Application no: H16-0288-11

Description: Alterations and extensions to existing two-storey dwelling to form two separate apartments

Location: 45 Bourne Road
Spalding
Lincs
PE11 1JN

Amendment: Internal layout modified (dwg. no. 10/261/PA/002)

FIRST FLOOR APARTMENT

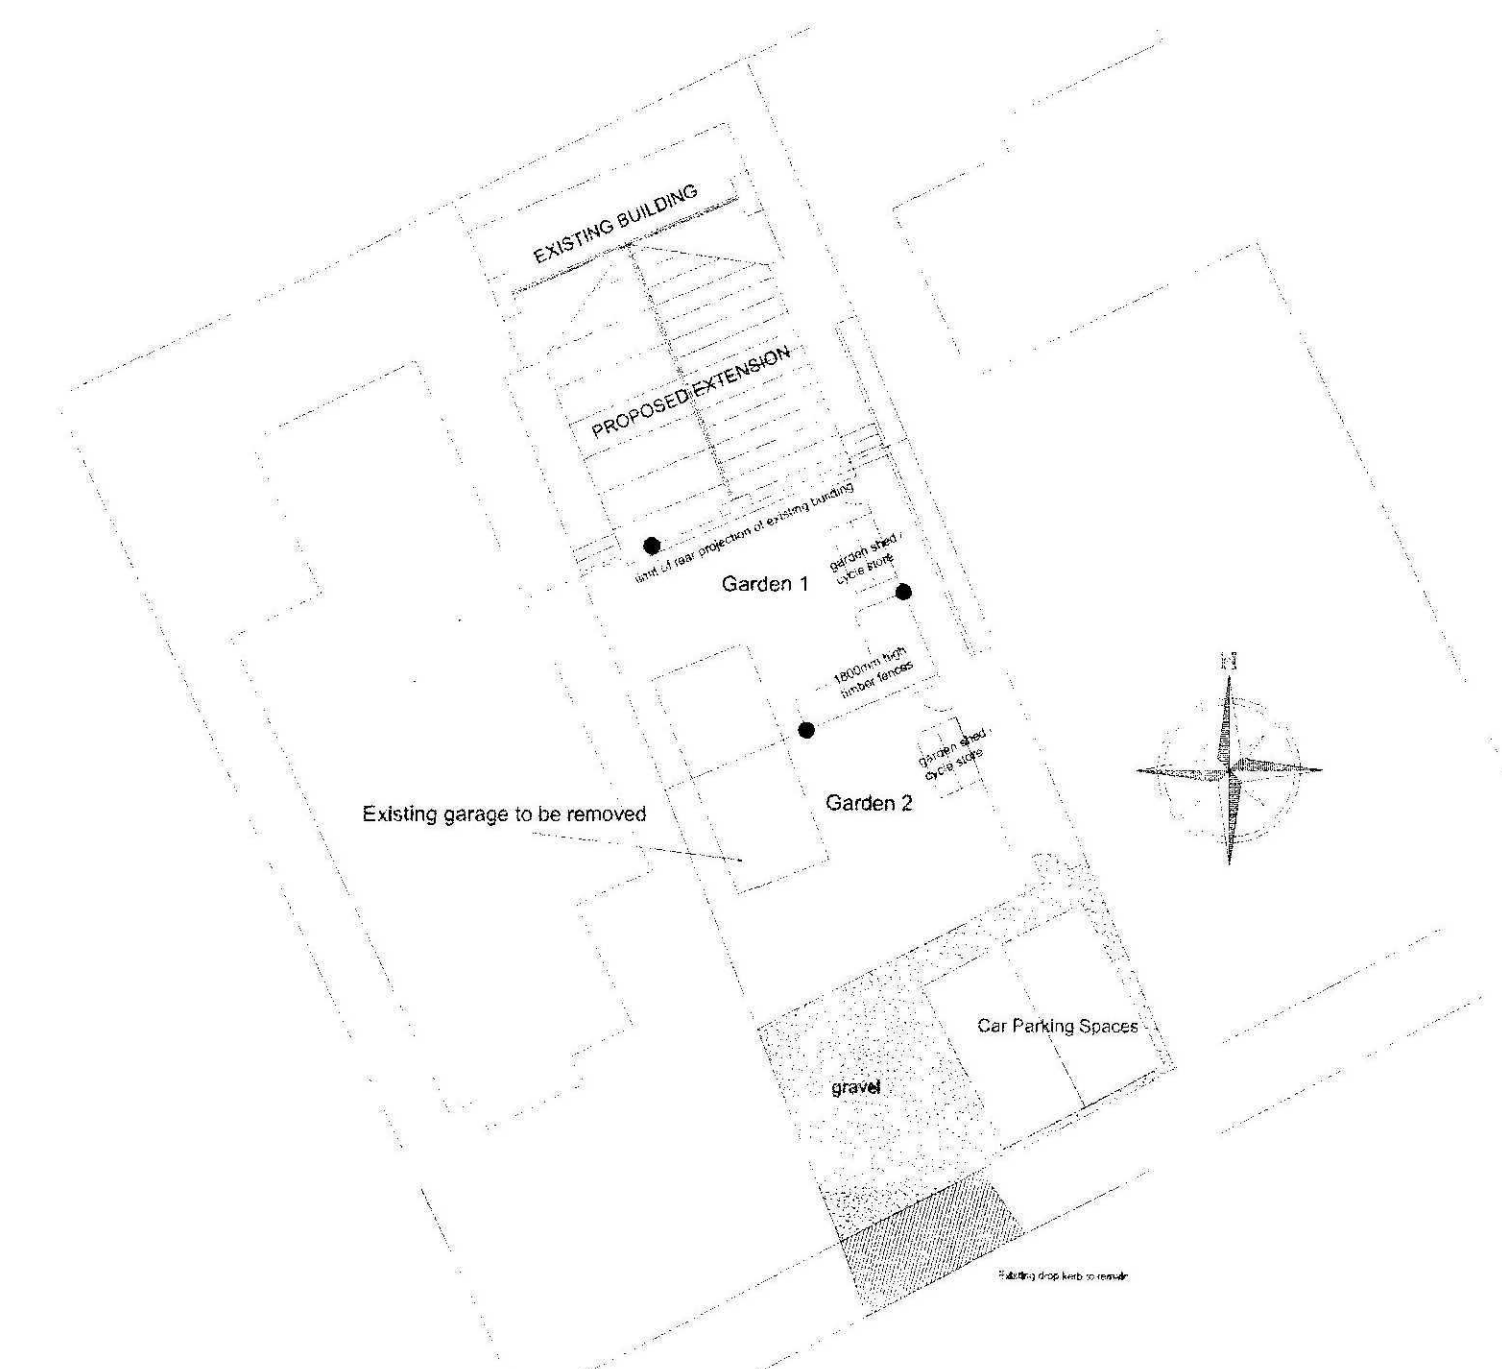
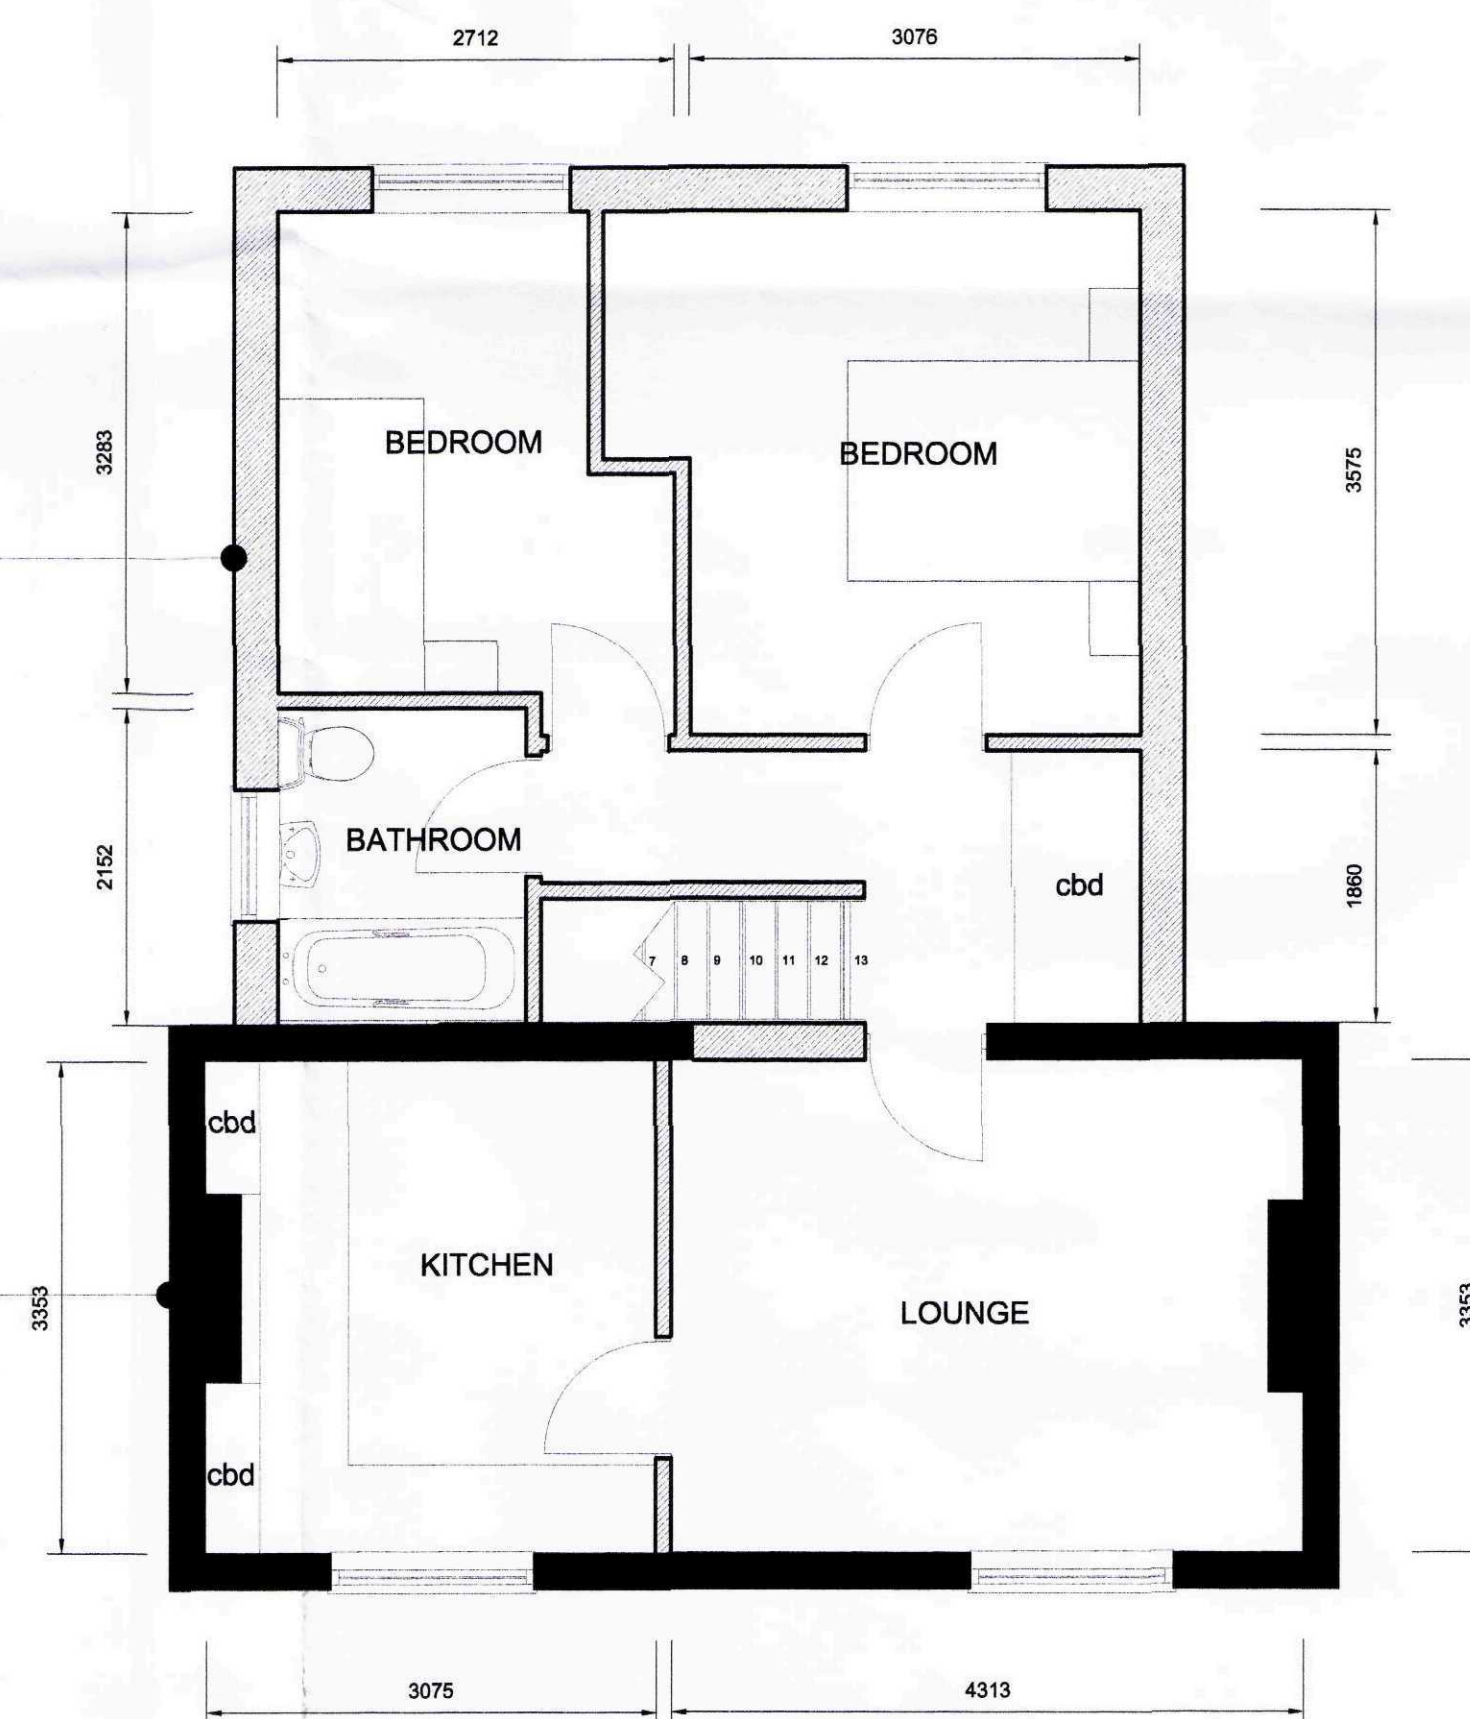
Although the kitchen and lounge areas meet the criteria for cooking eating and living given in our Residential Flat Conversions Policy dated February, 2010, the minimum internal dwelling area range is not quite met (57-67 square metres) and the two bedrooms on the first floor don't, I believe, meet the bedroom areas of 12 and 7 square metres.

- In apartment 1 I have chosen to show the storage area as the cupboards in the Kitchen. I am not sure whether this might be ducking the issue a little, although I would hope not. I am over-sized in both bedrooms however, by more than 1.5 sq m, which should allow for alternative storage provision sufficient to meet the requirements.
- Also in apartment 1, the overall area was 1.5 sq m below the minimum requirement, and so I have now shown an under-stair cupboard with an area of 1.5 sq m, which will deal both with storage allocation and overall floor area at a stroke.
- In apartment 2, I was marginally deficient in the double bedroom, but over-sized in the single bedroom. I have now nudged the dividing wall to bring the double bedroom up to 12 sq m, with a reduction in the single bedroom reducing its area to 8.12 sq m.

APARTMENT 1 – GROUND FLOOR	ACTUAL AREA – m ²	REQUIRED AREA – m ²
Lounge / Kitchen (CEL)	24.24	24
Double Bedroom	13.14	12
Single Bedroom	8.92	7
Dedicated Storage	4 in kitchen	1.5
Overall internal dwelling area	53.5	57 to 67
APARTMENT 2 – FIRST FLOOR		
Lounge / Kitchen (CEL)	24.24	24
Double Bedroom	11.82	12
Single Bedroom	8.3	7
Dedicated Storage	4 in kitch + 1.6 in hall	1.5
Overall internal dwelling area	58.7	57 to 67
